DISAPPROVED
Plan Review

SITE PLAN

PROPOSED FUJIMOTO RESIDENCE
100 AJO WAY
MONUMENT COLORADO 80132

PROJECT 3490
SHEET
A1 OF 12

## SITE PLAN

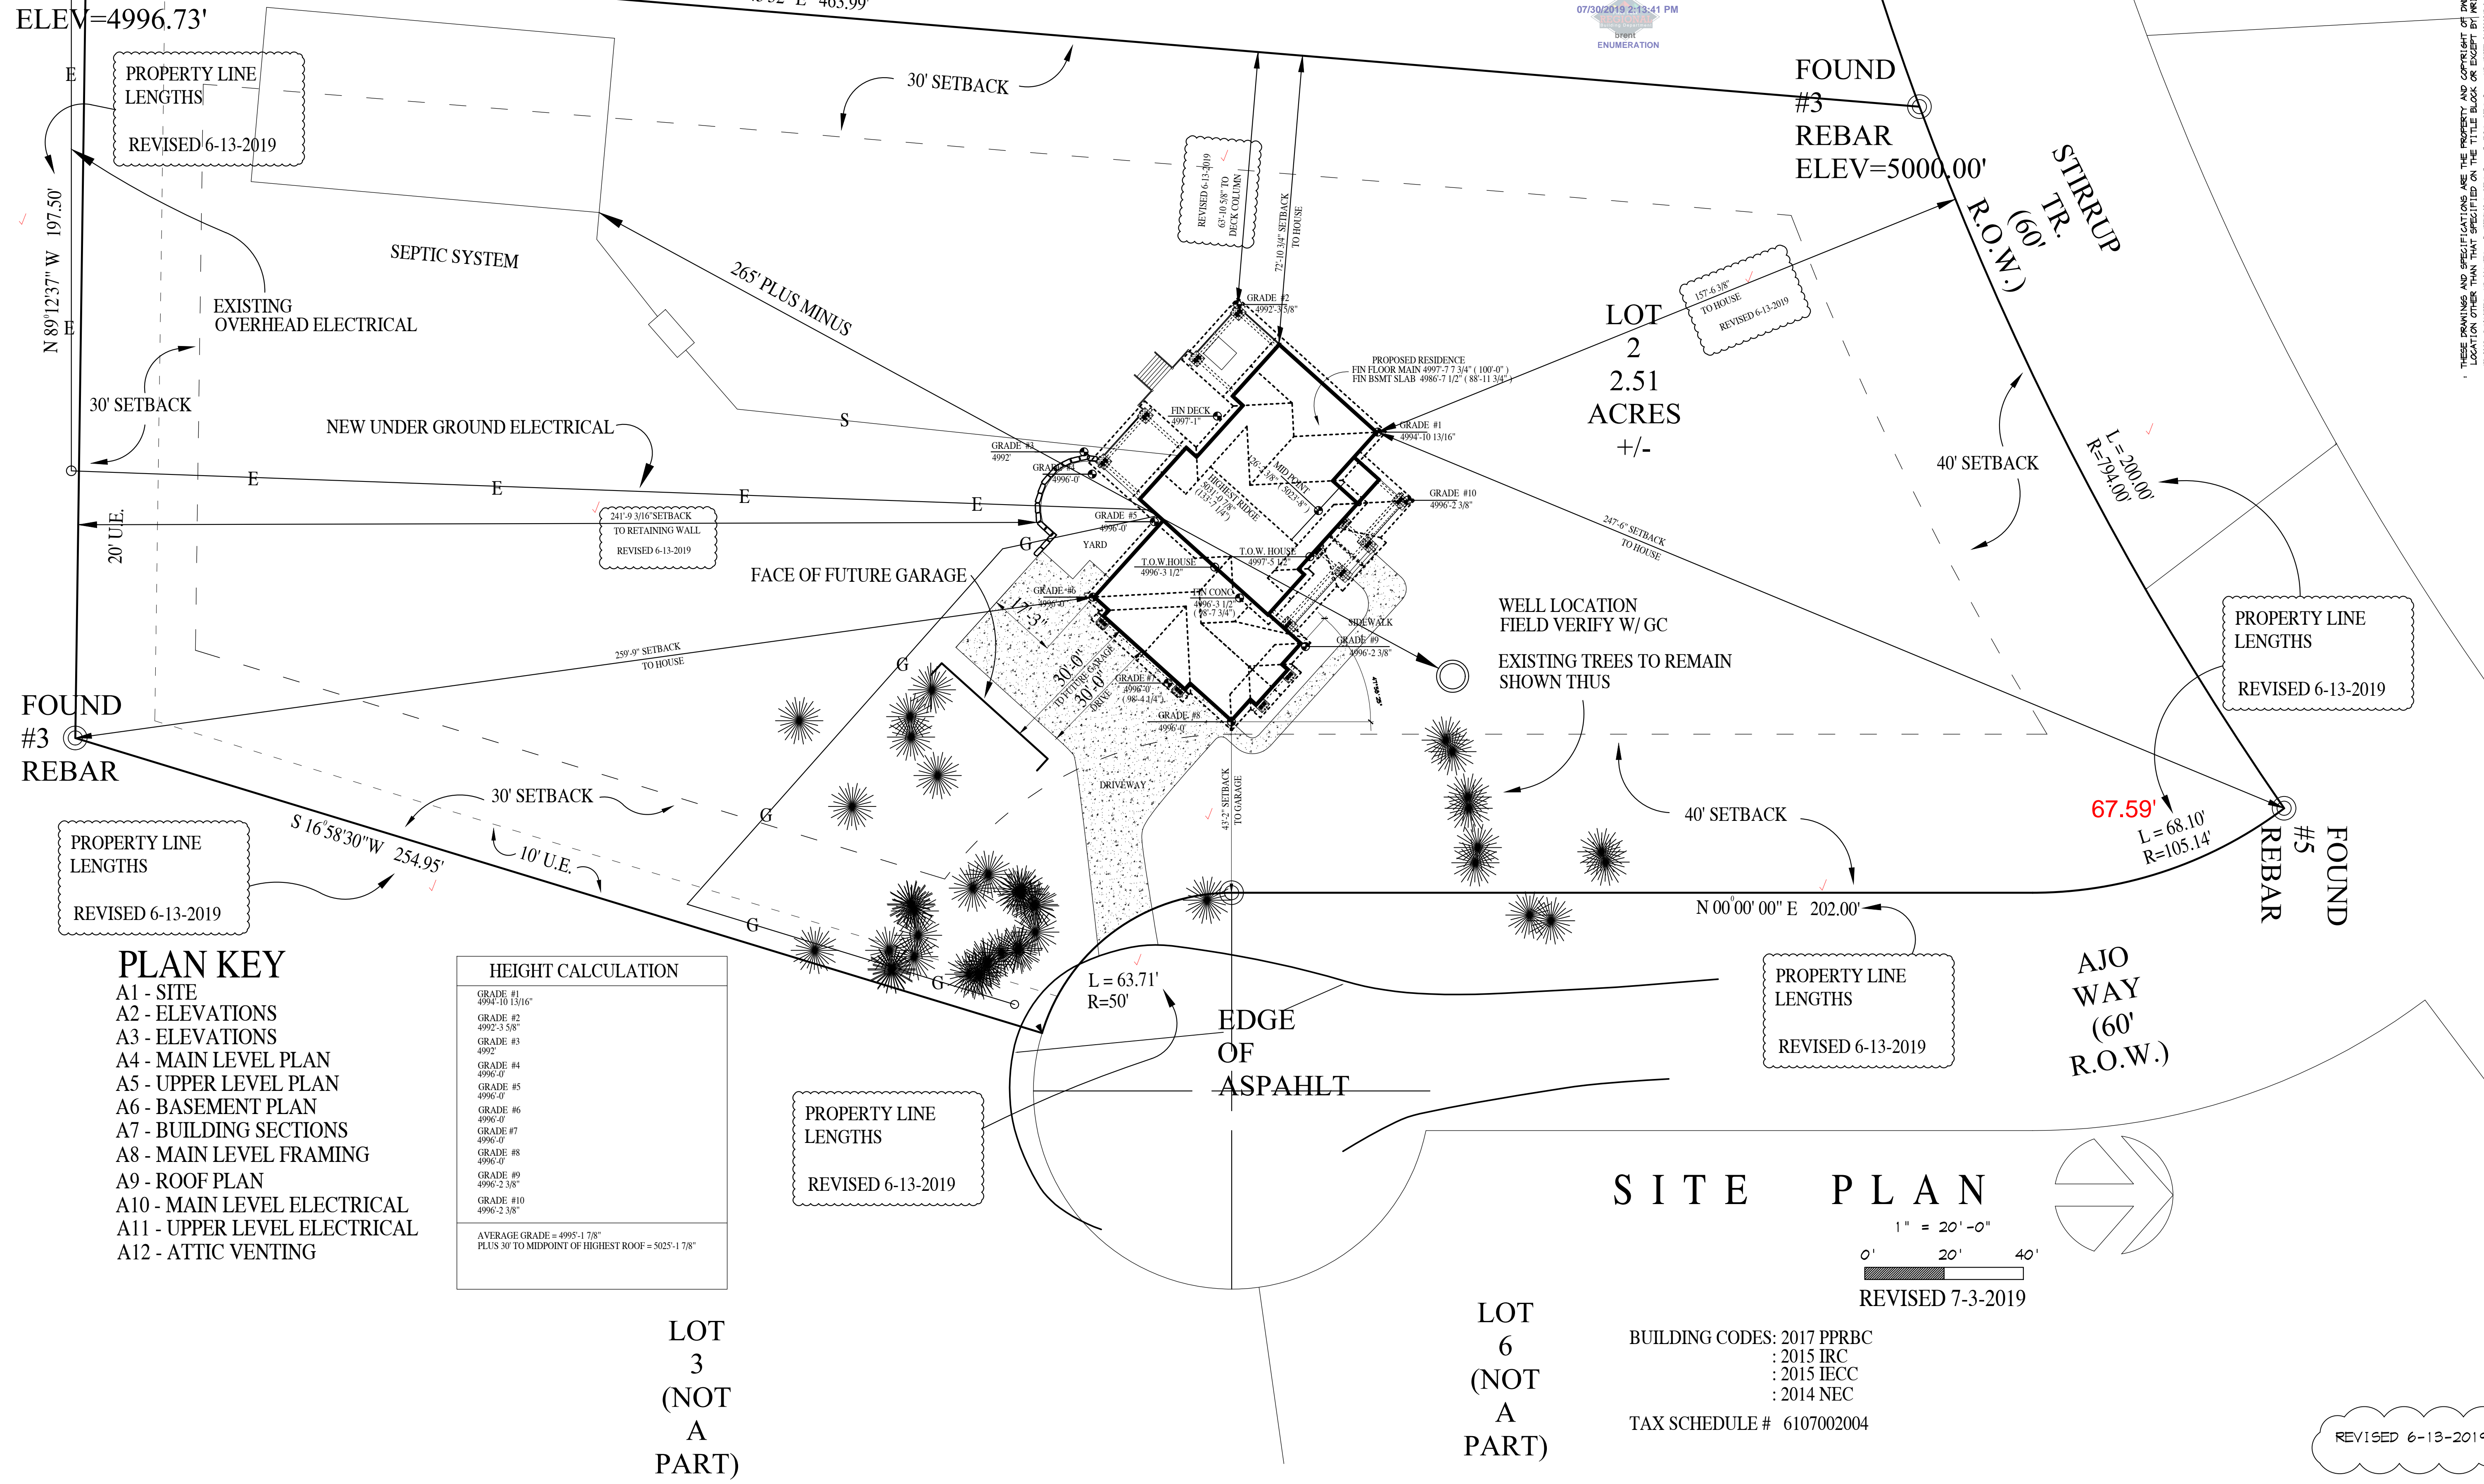
- (1) add distance measurements of property line to structure
- (2) add property line length measurements
